# PORTLAND MAINE

June 12, 2007

RE: 351 Forest Avenue – 112 D001 – B-2 – awnings

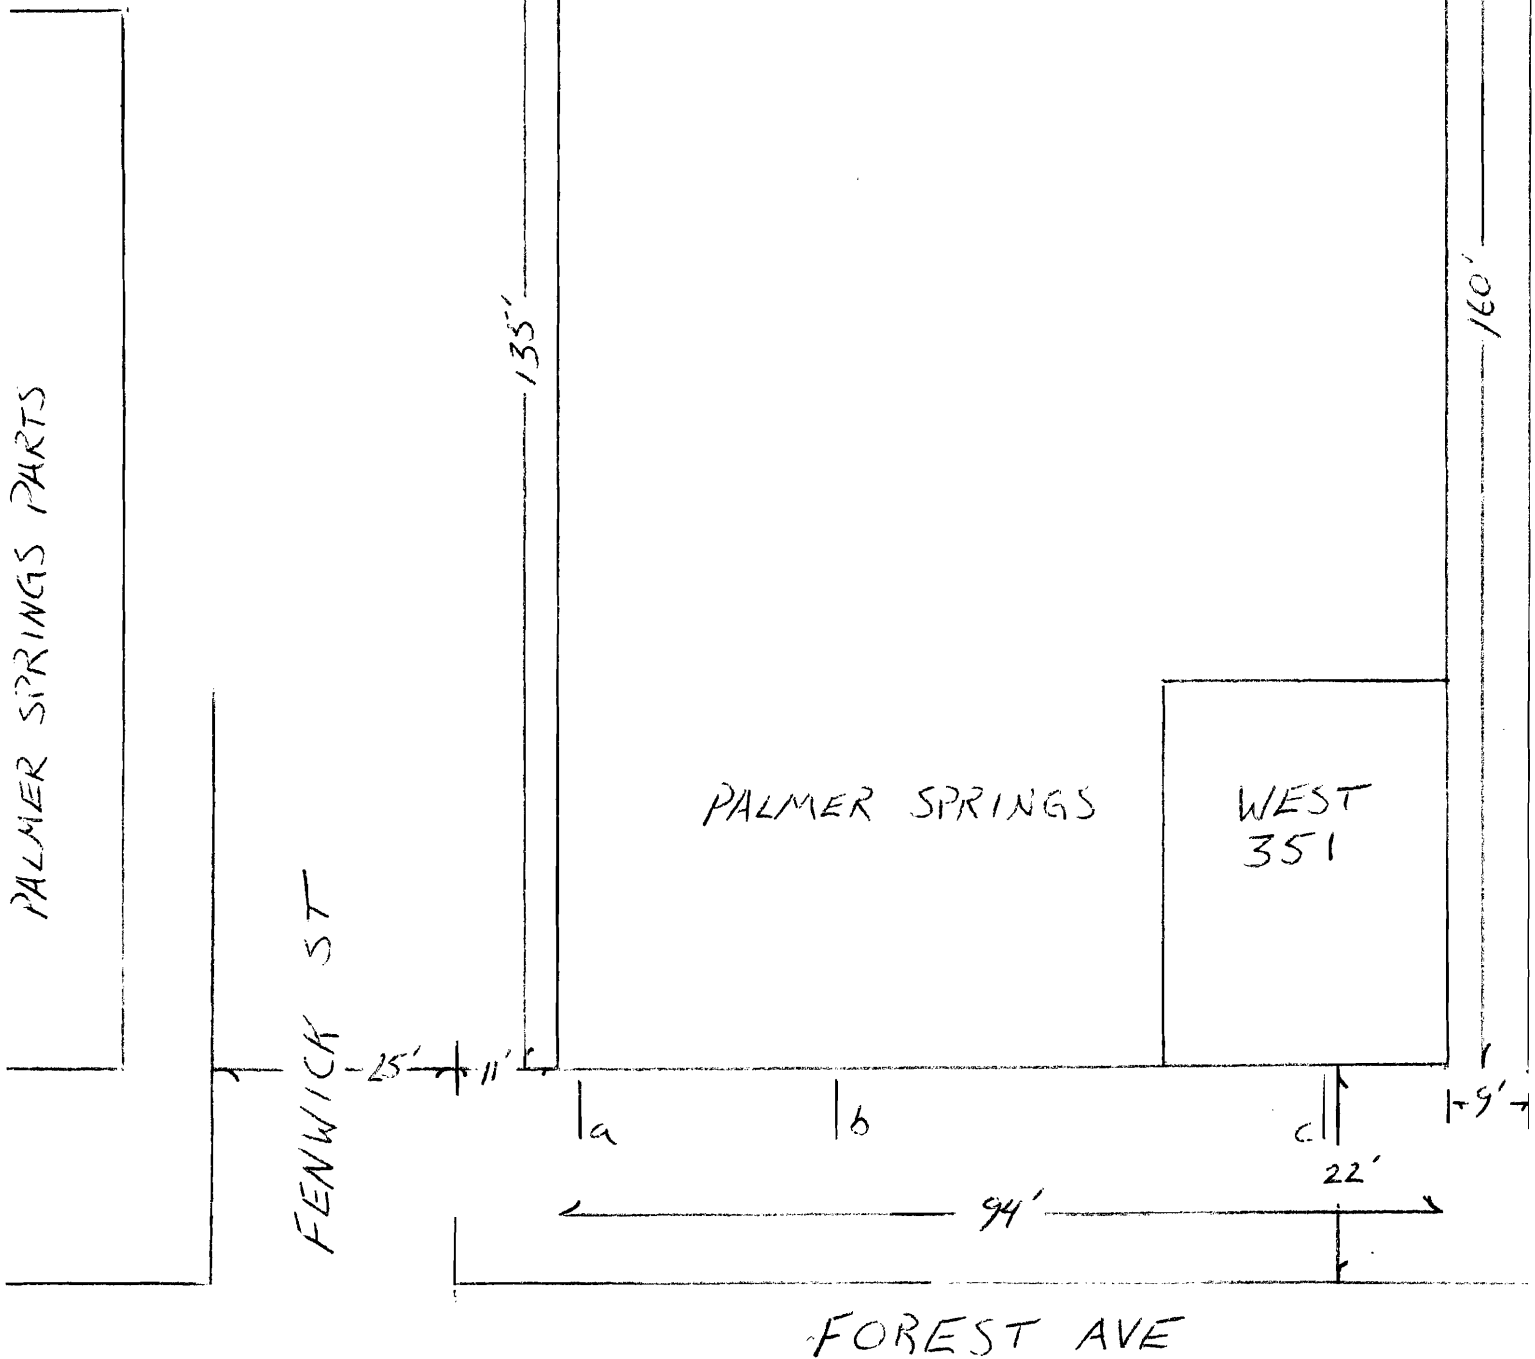
Section 14-369.5, Table 2.13 of the ordinance specifies the size and amount of signs that a business can have in the B-2 zone for a multi-tenant lot. An individual tenant is allowed one building sign. Since each awning has the logo for your business, they are considered two separate signs.

You have thirty days from the date of this letter to apply for a permit after the fact for the two awnings. As part of the application, you need to include the square footage of the logo on one of the awnings. You also need to indicate which logo is being removed, since you can only have a logo on one awning. If we do not receive a signage/awning permit application within thirty days, you will have to remove the awnings. I have enclosed a signage/awning permit application.
